CITY OF ALBUQUERQUE

**Re: Advance Auto Parts
2801 4th St NW
Request for Permanent C.O. - Accepted
Engineer's Stamp dated: 9-15-15 (H14D041)
Certification dated: 3-21-16**

RE: Advanced Auto Parts (File: H14D041)
Grading and Drainage Plan , Engineer's Stamp Date 8-17-2015
Engineer's Certification Dated 3-21-16

**RE: Advanced Auto Parts
Grading and Drainage Plan
Engineer's Stamp Date 9-15-2015 (File: H14D041)**

C-101

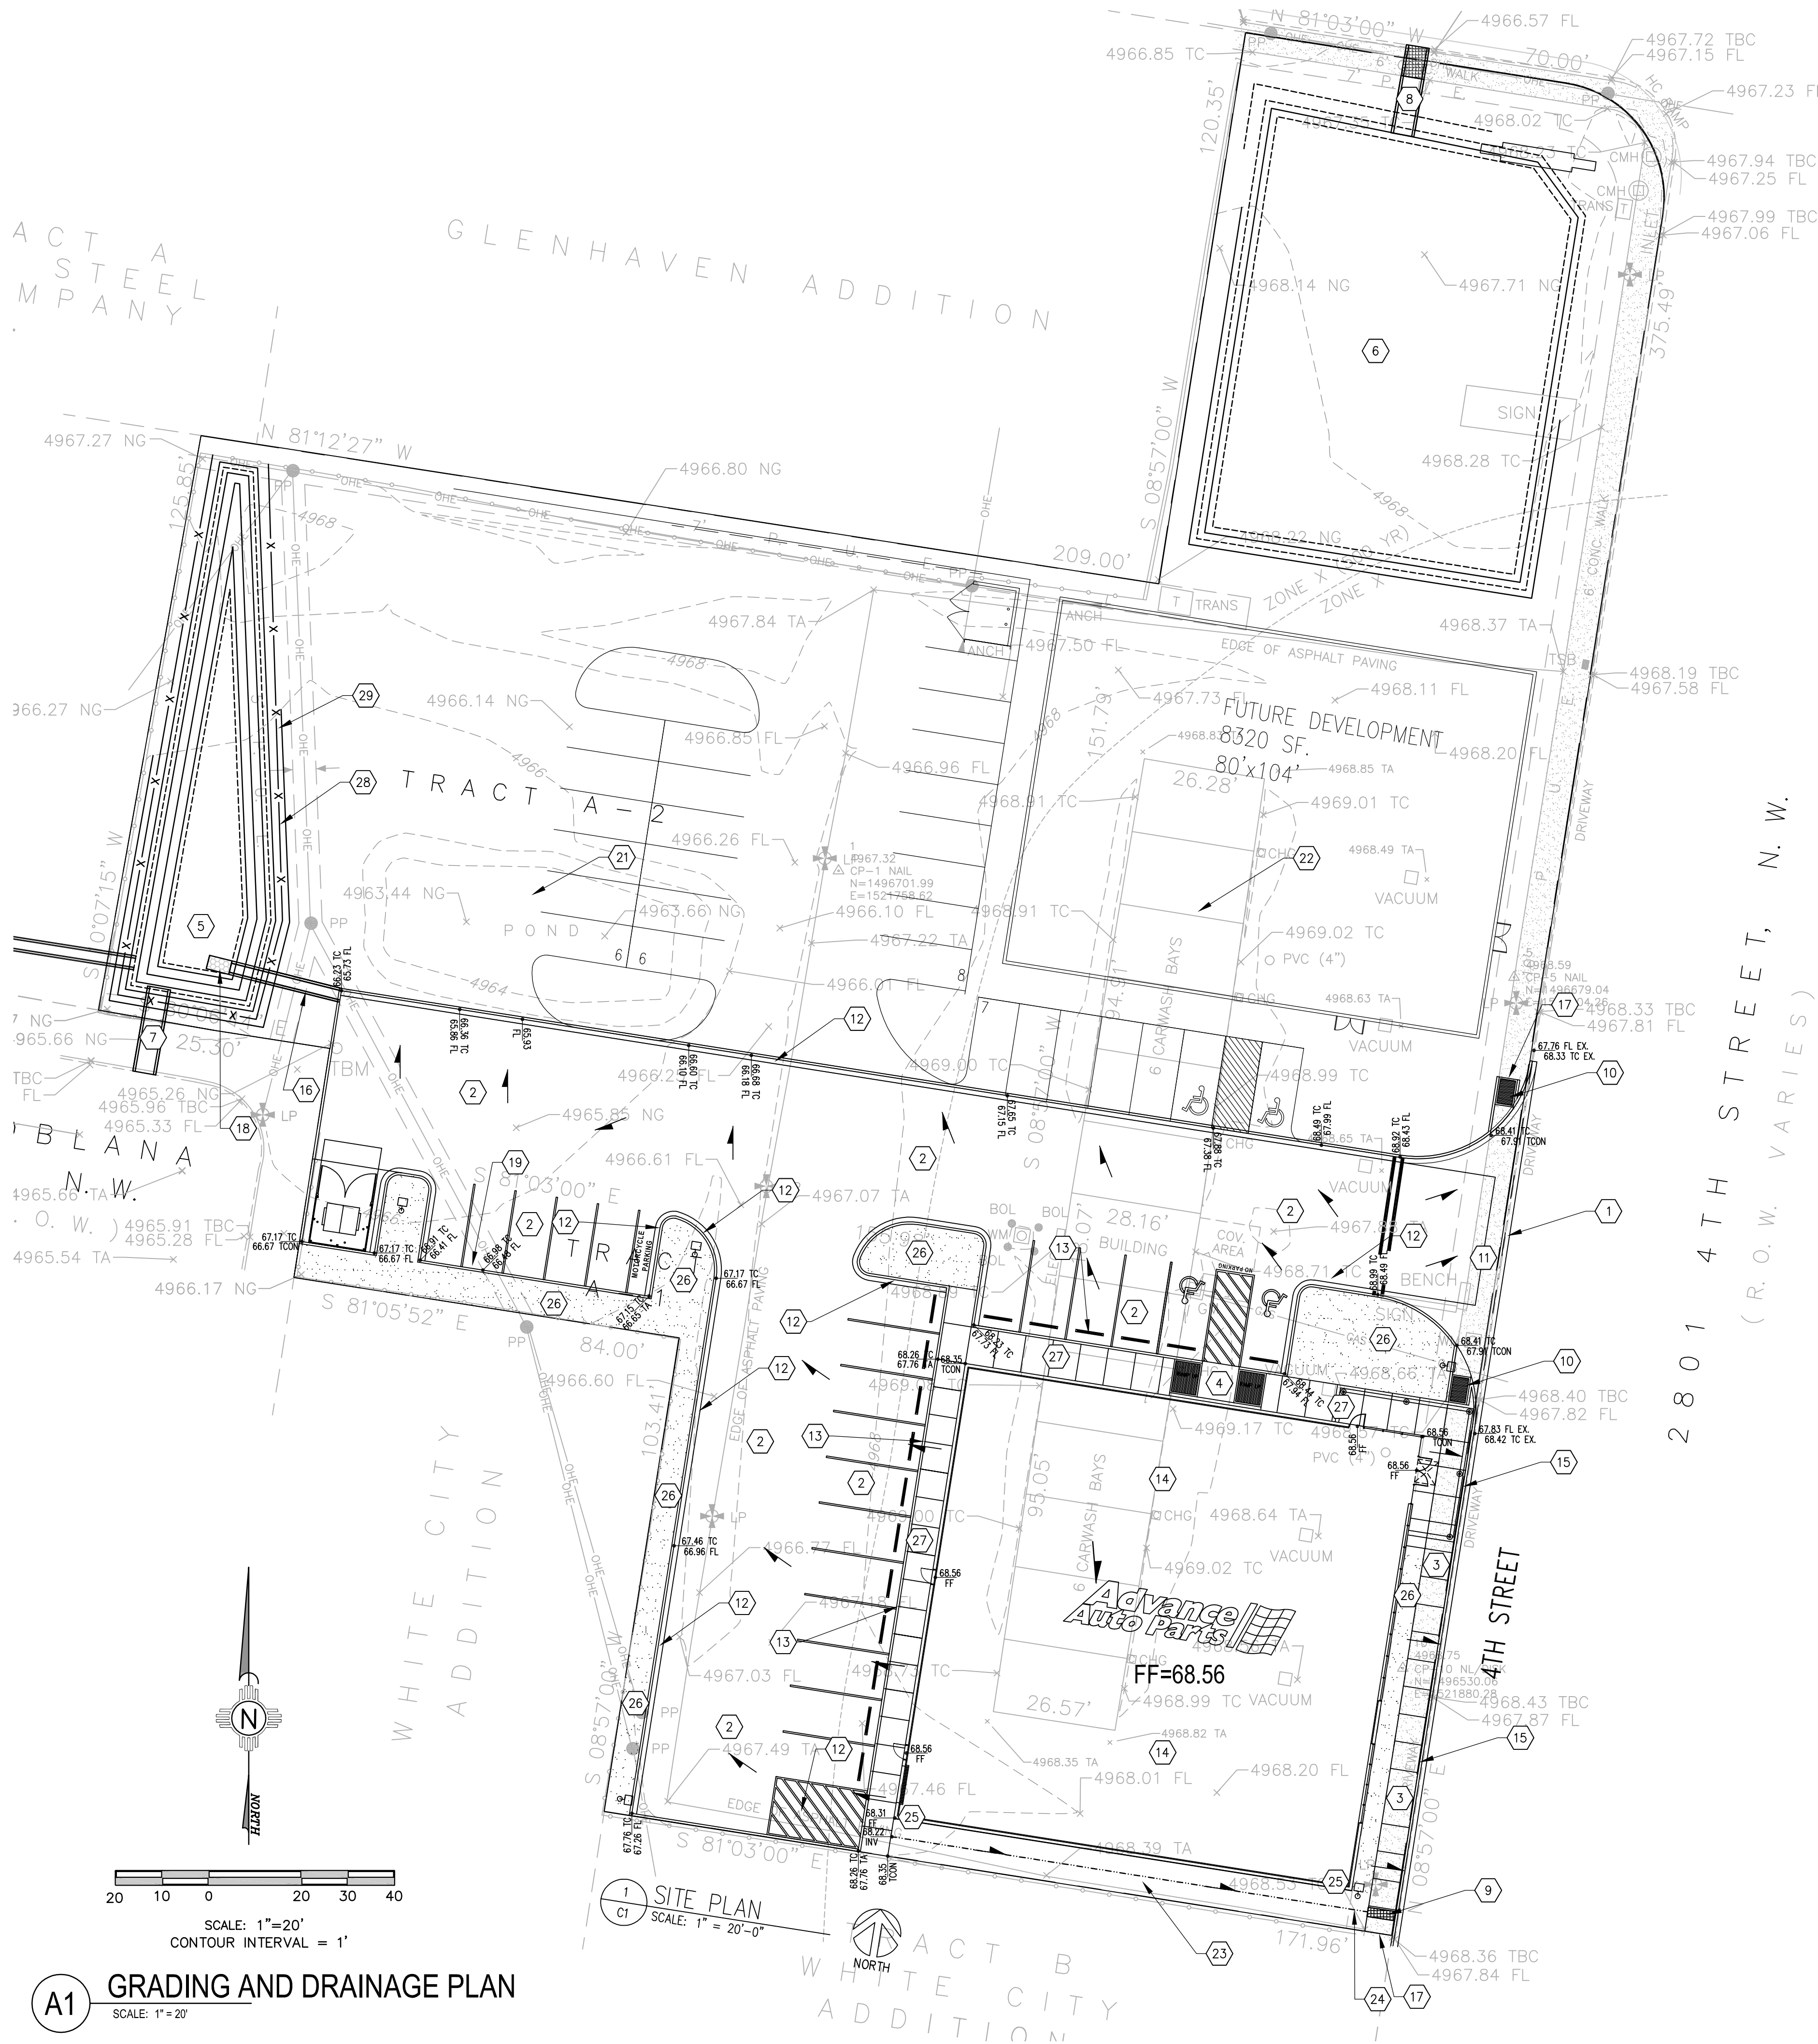
- a. Grading and Drainage plan with supporting calculation for the *Final Developed condition*. Dwg. C-102 is essentially this Final Condition Plan. However, the following needs to be corrected:

- i. Remove the Curb and Gutter separating the two properties, and show only the intended final condition.
 - ii. Show intended elevations/contours in the future parting lot

- iii. How will flows be directed to the pond in the final condition without the curb and gutter?
 - iv. Show the intended roof discharge points and direction of the future building

- v. Since full Retention ponds must retain the 100yr-10day volume, with 1 ft. of freeboard, Pond #1 is undersized.
 - vi. Future Pond #2 should be a detention pond, only retaining the First Flush and then discharging at a rate of 2.75cfs/Ac. The discharge mechanism will need to be designed.

- b. Grading and Drainage plan with supporting calculations for the *Interim condition*. Provide a plan with just the development intended to occur under this Building Permit. Show:

- i. The Curb and Gutter that separates the phases (in i. above)
 - ii. How will the remaining site be graded in the interim? How and where will it discharge to?

- iii. Provide drainage calculations for the remainder of the site in the Interim state.
 - iv. Pond #1 can be designed for just the "Interim Condition" (100yr-10day volume), and then enlarged later. It is up to you. But if the property is divided, the drainage easement must cover the "final condition" pond footprint.

3. For both Ponds: Show contour labels, Bottom of Pond elevation, Max WSEL, Provided Volume and Required Volume. (Show this on both the Interim and Future G&D plans, as it may be different)

4. Roof flows from the Advance Auto Parts must be directed to a first flush pond before discharging to swale along the south boundary. Perhaps the hatched area (handicap ramp?) at SW corner of the building can be used as such.

✓ This new curb and gutter will need to be installed as part of the current phase to divert storm water to the new Retention pond. Once phase 2 is developed the Curb and Gutter will be removed and replaced with new Concrete Valley Gutter that will receive storm water from the north and the south and divert into new retention pond. See sheet C-101.

✓ Please see sheet C-101, for future flow arrows and future finish floor on building. This plan shows the general drainage concept of the future development.

This new curb and gutter will need to be installed as part of the current phase to divert storm water to the new Retention pond. Once phase 2 is developed, the Curb and Gutter will be removed and replaced with new Concrete Valley Gutter that will receive storm water from the both the proposed and future developmment and divert into new retention pond.

- ✓ iv. Show the intended roof discharge points and direction of the future building.
Please see sheet C-101 for future building roof discharge points and the direction of the roof flows.

Please see Sheet C-001 for the calculations for the 100yr-10day required volume and the pond volume calculations for Pond #1, showing it retains the required volume at 64.5 elevation which is 1' below the spillway (freeboard). See Sheet C-102 for the newly designed Pond #1.

Future Pond # 2 retains the 100-Year-24 hour storm which is extremely conservative in that it exceeds the 1/2" retention requirement in the Valley (per COA Hydrology Staff Valley Rule). The overflow future devise is a concrete channel and a standard 24" sidewalk culvert.

There will be a ditch that will divert water from the north to the new retention Pond #1. See sheet C-102.

3. For both Ponds: Show contour labels, Bottom of Pond elevation, Max WSEL, Provided Volume and Required Volume. (Show this on both the Interim and Future G&D plans, as it may be different :
See sheet C-102 for contours and key notes for Pond information.

4. Roof flows from the Advance Auto Parts must be directed to a first flush pond before discharging to swale along the south boundary. Perhaps the hatched area (handicap ramp?) at SW corner of the building can be used as such:
See sheet C-102. Roof drains diverted to northeast corner of new building then diverted into new first flush Pond #3.

D4 CONCRETE CHANNEL DETAIL
SCALE: NOT TO SCALE

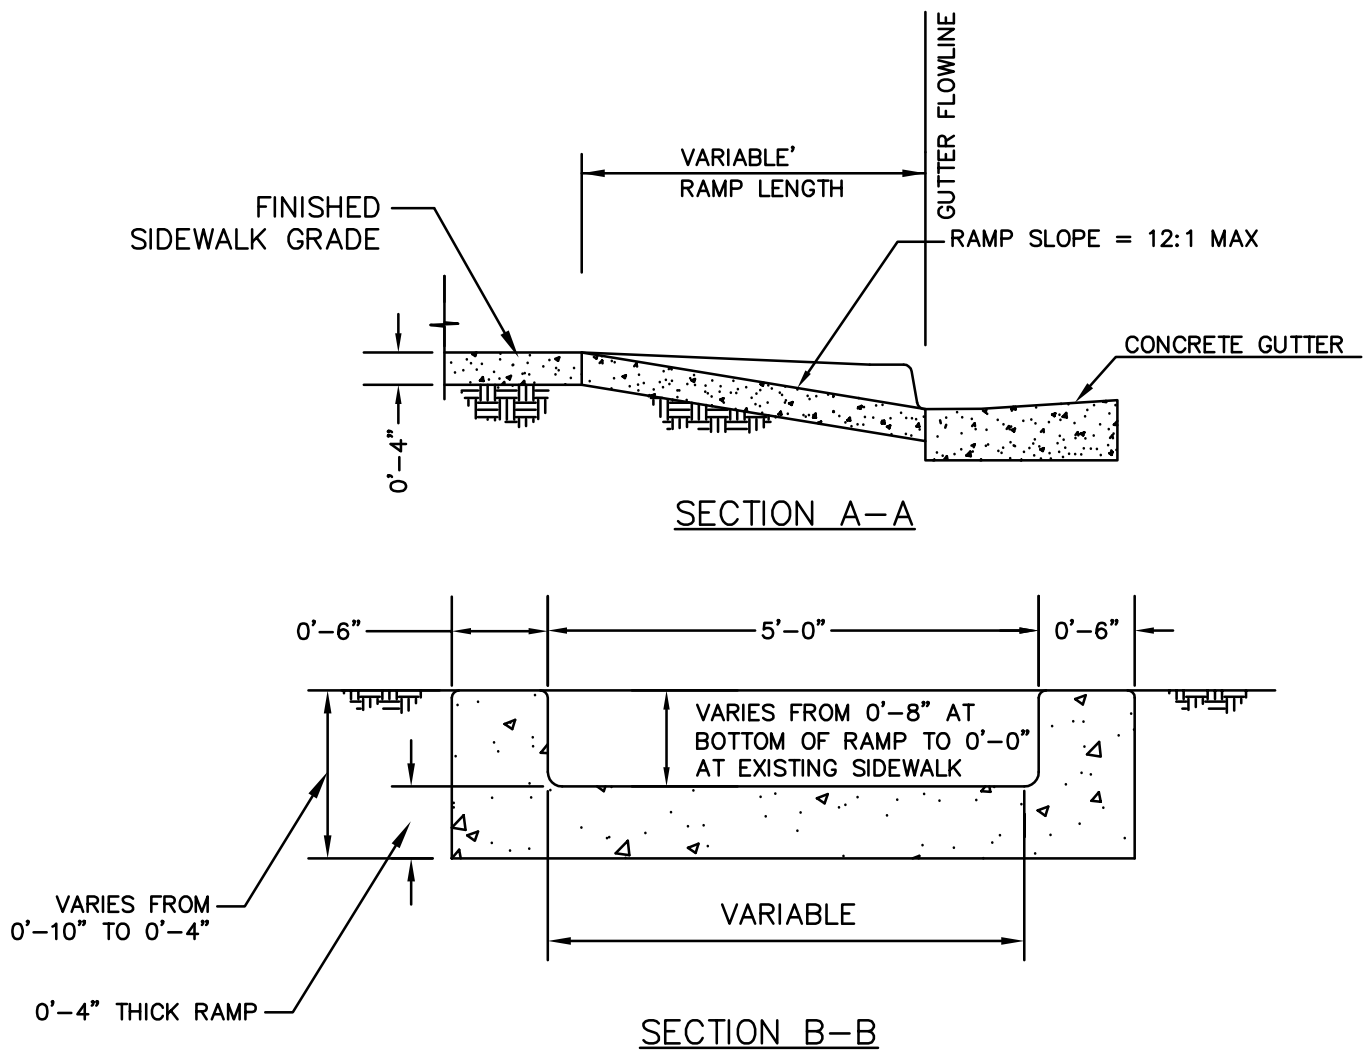
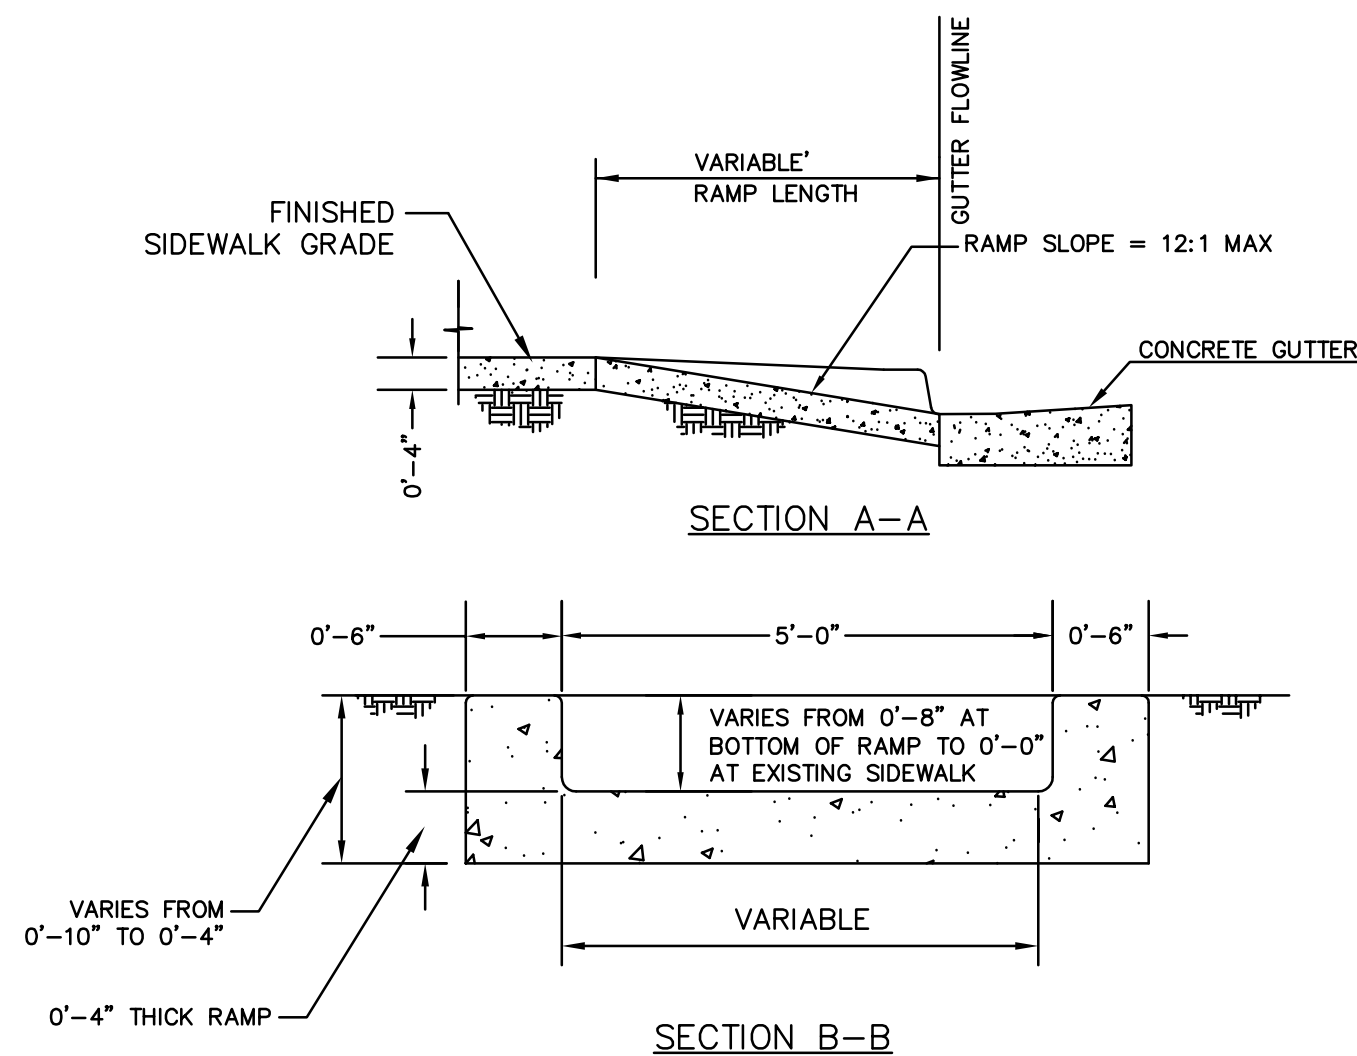
1. Keyed note #9 must be modified to add that the SW culvert (both plate and channel) must be extended 2ft. past the back of Sidewalk. Note that the bolts must be tack welded to the plate.
2. Keyed note #7 must be modified. An open concrete channel presents a tripping hazard. If there is sidewalk, then a Sidewalk culvert should be used (extended per above comment). It is unclear if there is Sidewalk. If there is not sidewalk, then the channel should be an earthen channel filled with riprap to avoid falling into it.

5. Provide calculations that size the SW culvert(s), the concrete swale. What is the WSEL?
6. Keyed notes should refer to the Detail on the Sheet C-501 (ie. See Detail D4 on Sht C-501)

6. Keyed notes should refer to the Detail on the Sheet C-501 (ie. See Detail D4 on Sht C-501):
See key notes on sheet C-102 and details on sheet C-501.
7. Pond #2 has a 2:1 slope. More than a 3:1 slope required slope stabilization measures. Large cobbles are typically used.:
6" of 2"-3" cobble stones will be used for stabilization measures. See sheet C-102 for key note and C-501 for detail.
